From: Zac Denton <Zac.Denton@arun.gov.uk>
Sent: 21 April 2020 11:30
To: Planning.Responses <Planning.Responses@arun.gov.uk>
Subject: FW: AB/11/20/DOC

Consultation response

AB/11/20/DOC

PROPOSED - GROUND FLOORS
New & Replacement Doors Elevations

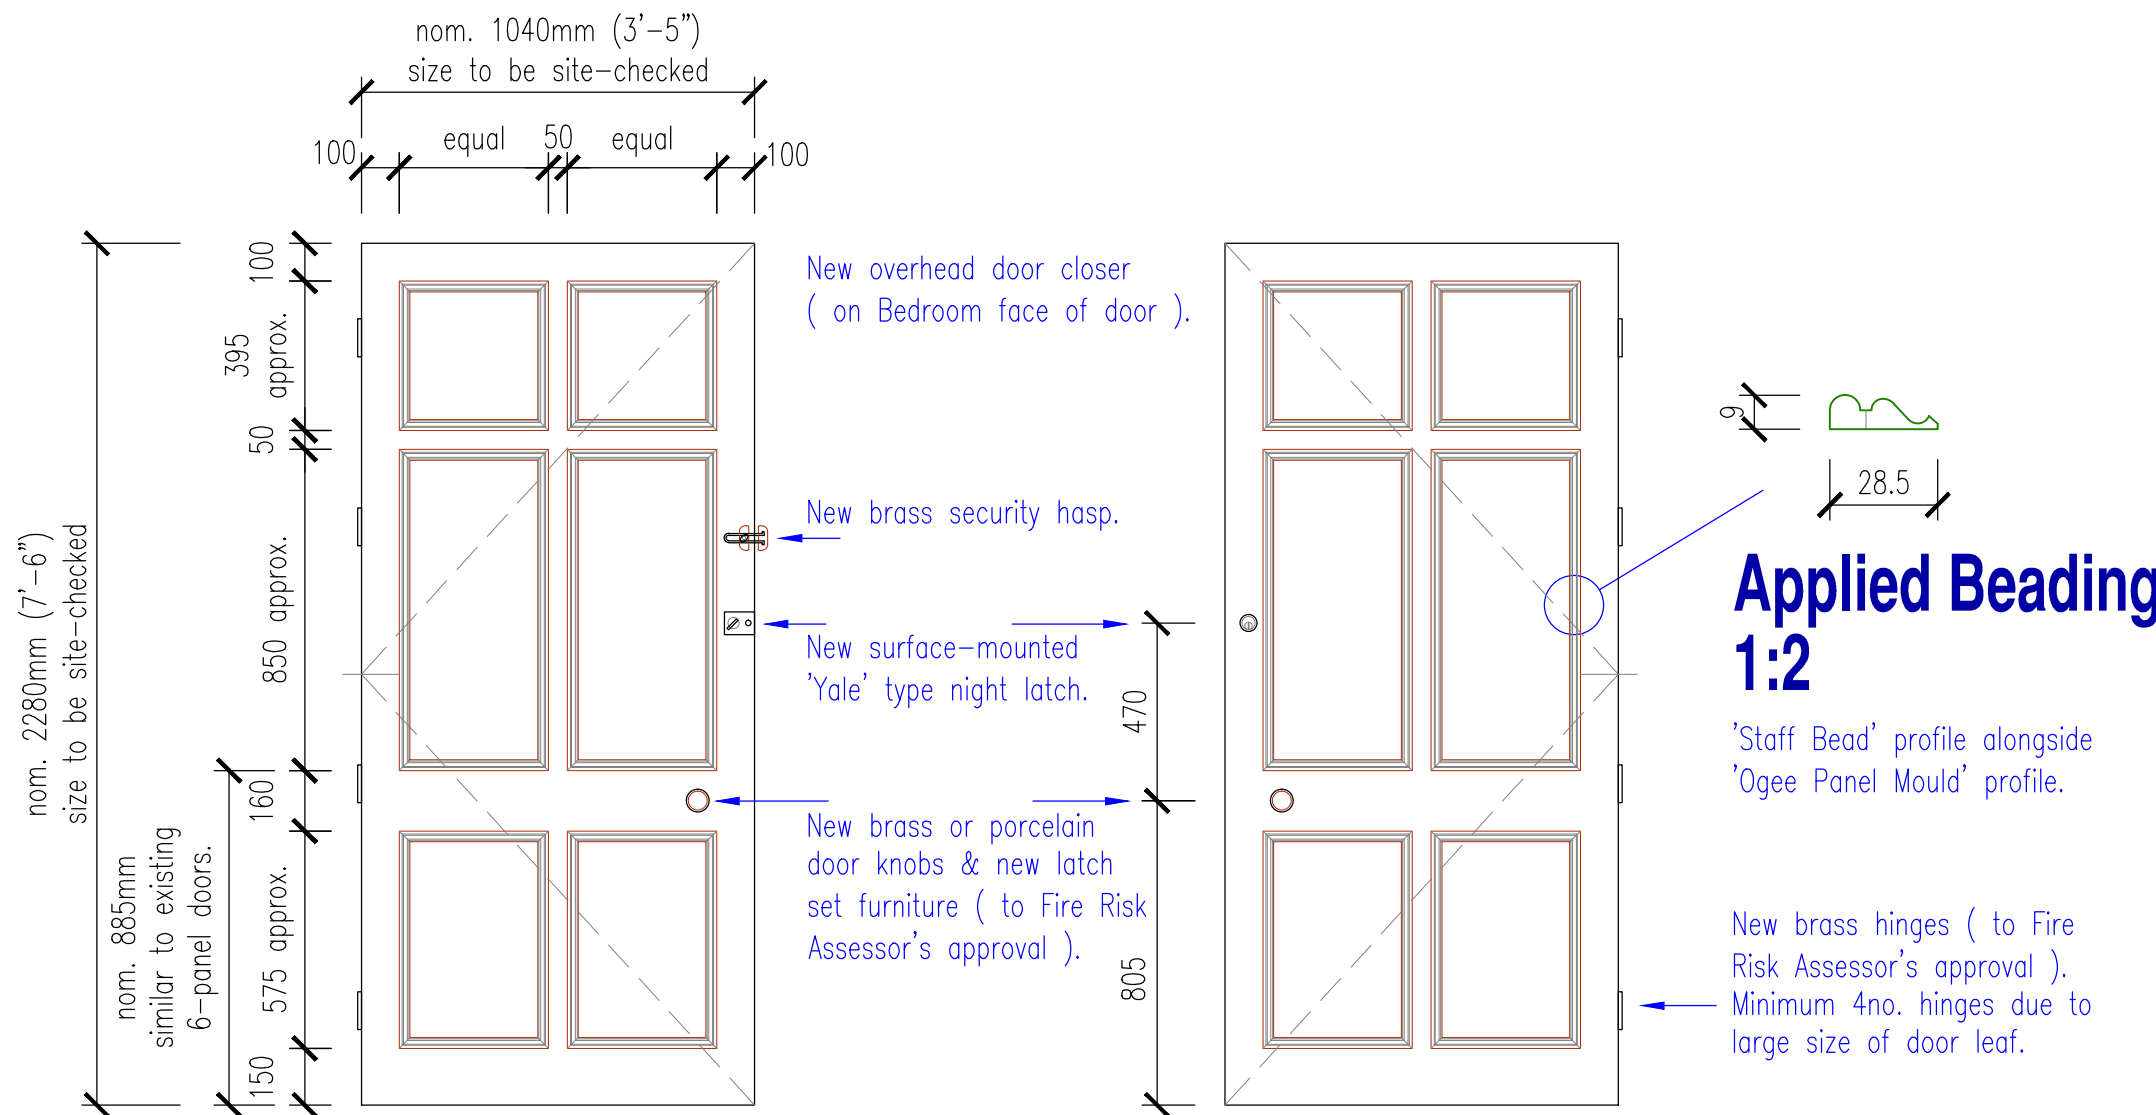
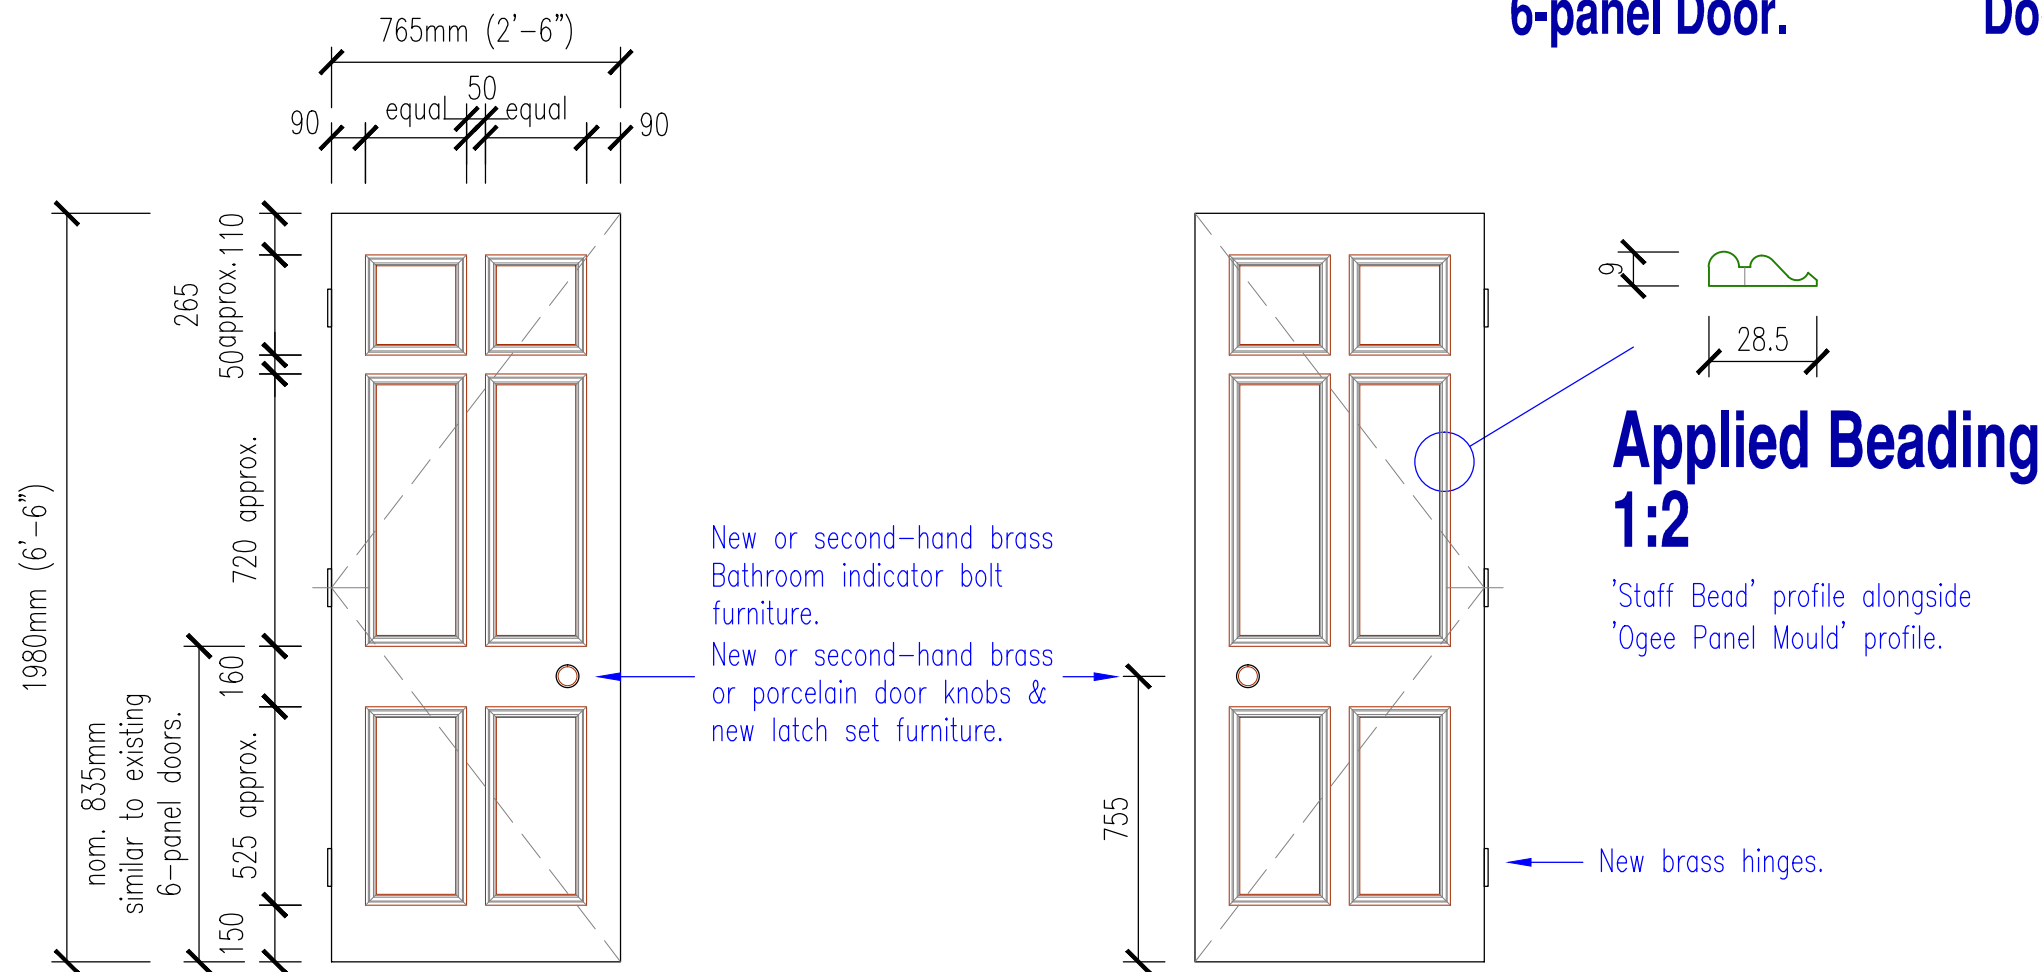
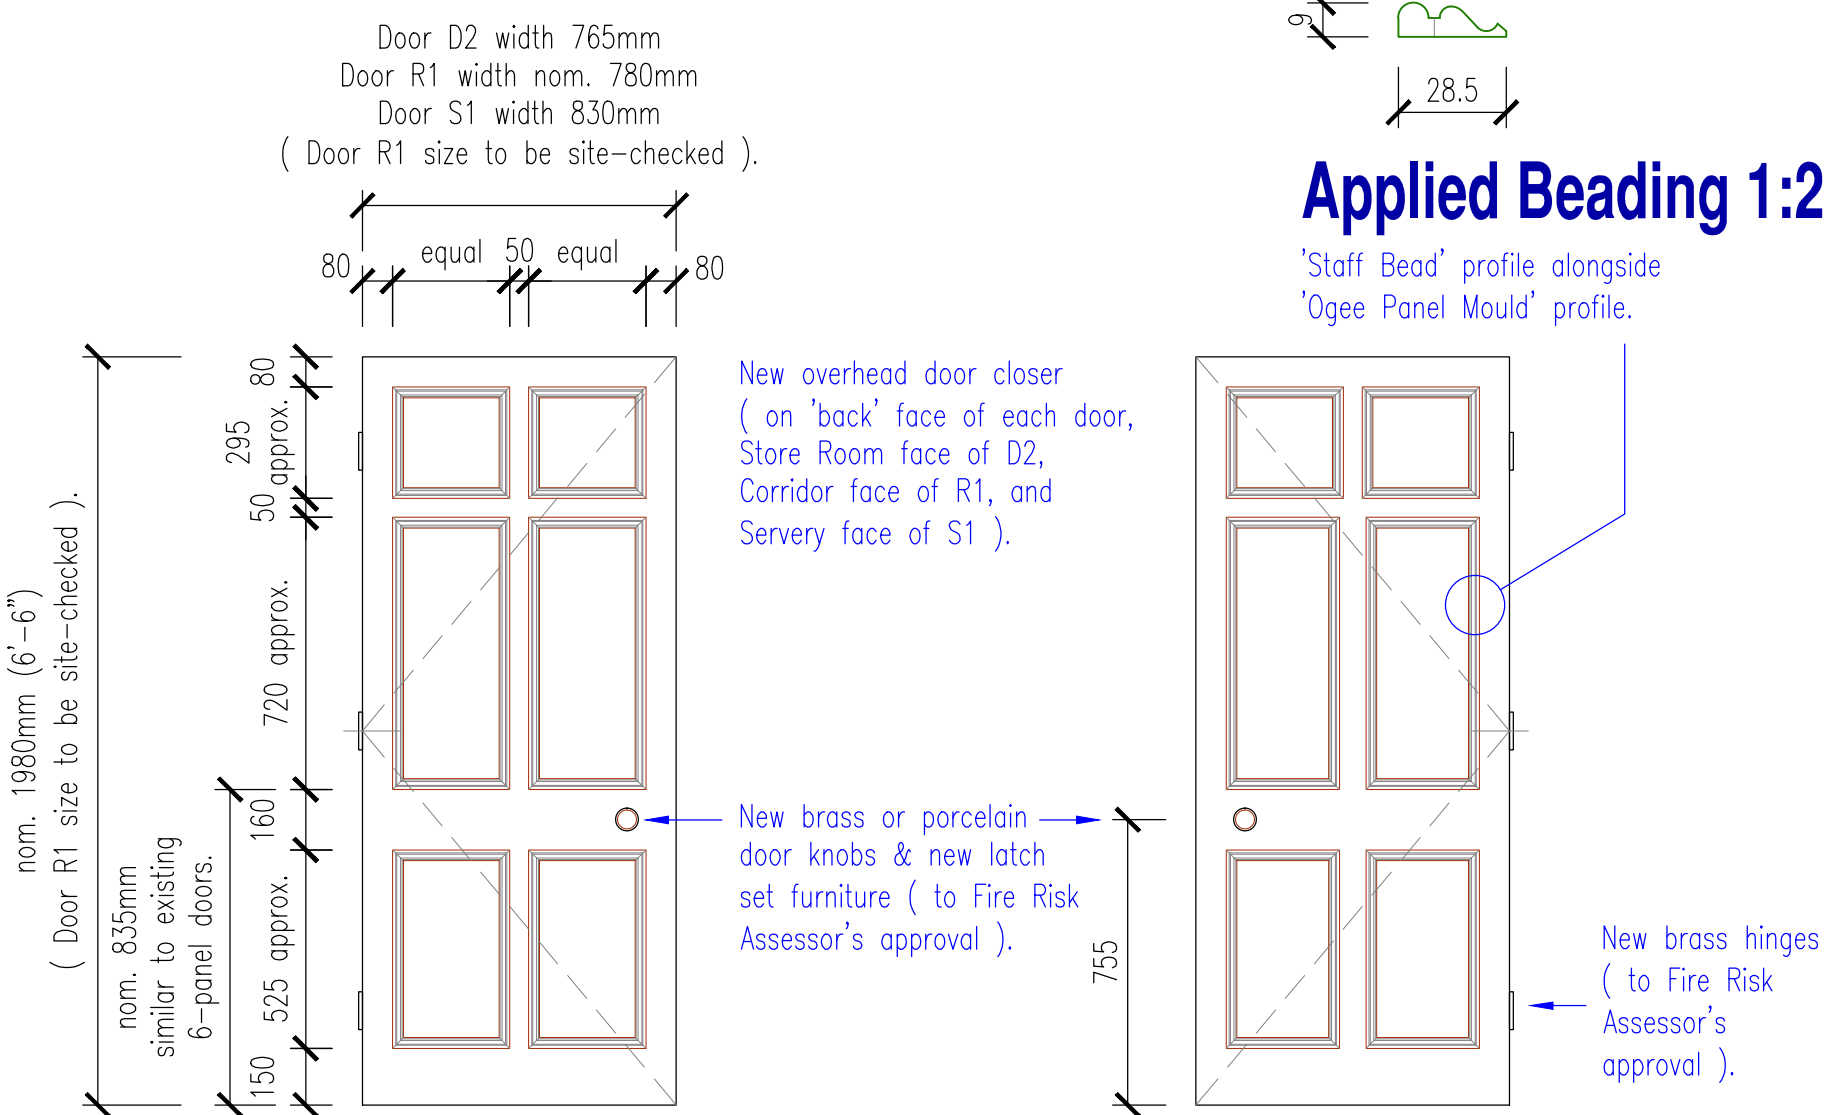
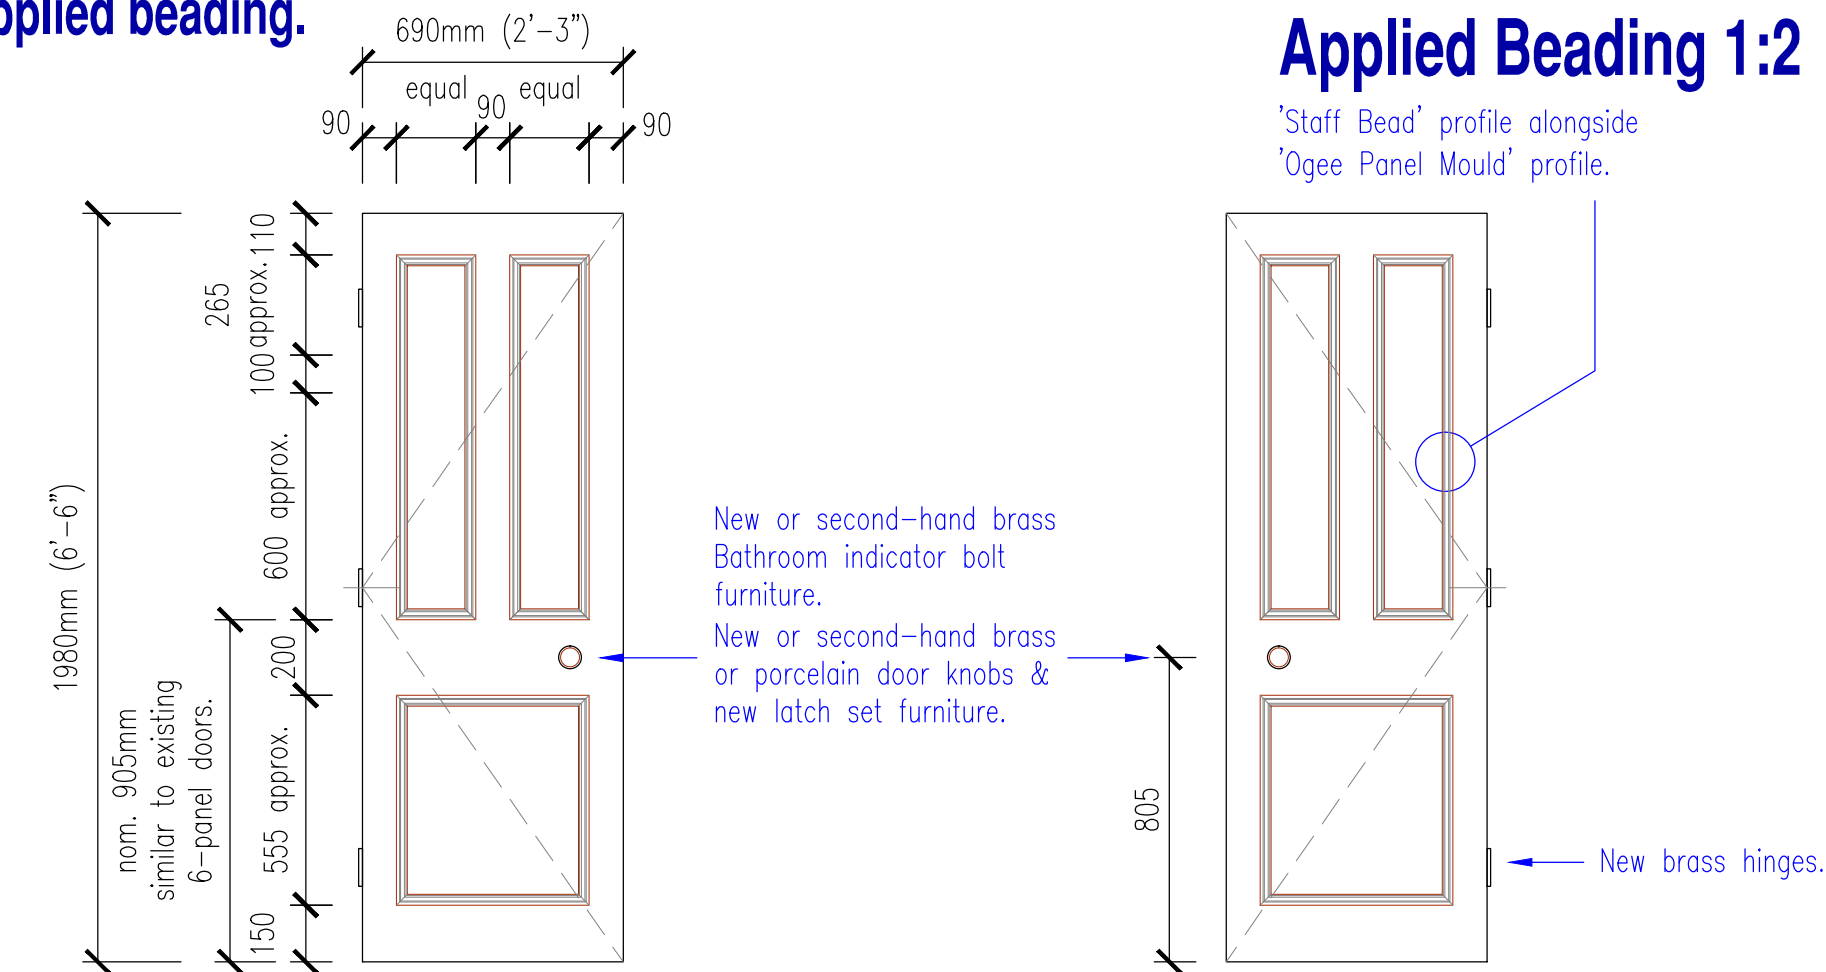
Whilst the elevations of the proposed doors appear to reflect that of others within the building, it is unfortunate that they are flush faced blank doors with applied moulding beads, as opposed to being of traditional construction. The effect is a door of limited aesthetic appearance.

I have to state that I do not have the knowledge of how to deal with fire prevention etc. and these comments are made on that basis. It would be preferred if doors of traditional construction/appearance could be used along with Intumescent Products or similar. However, if the proposed doors provide the required safety benefits, they could be supported.
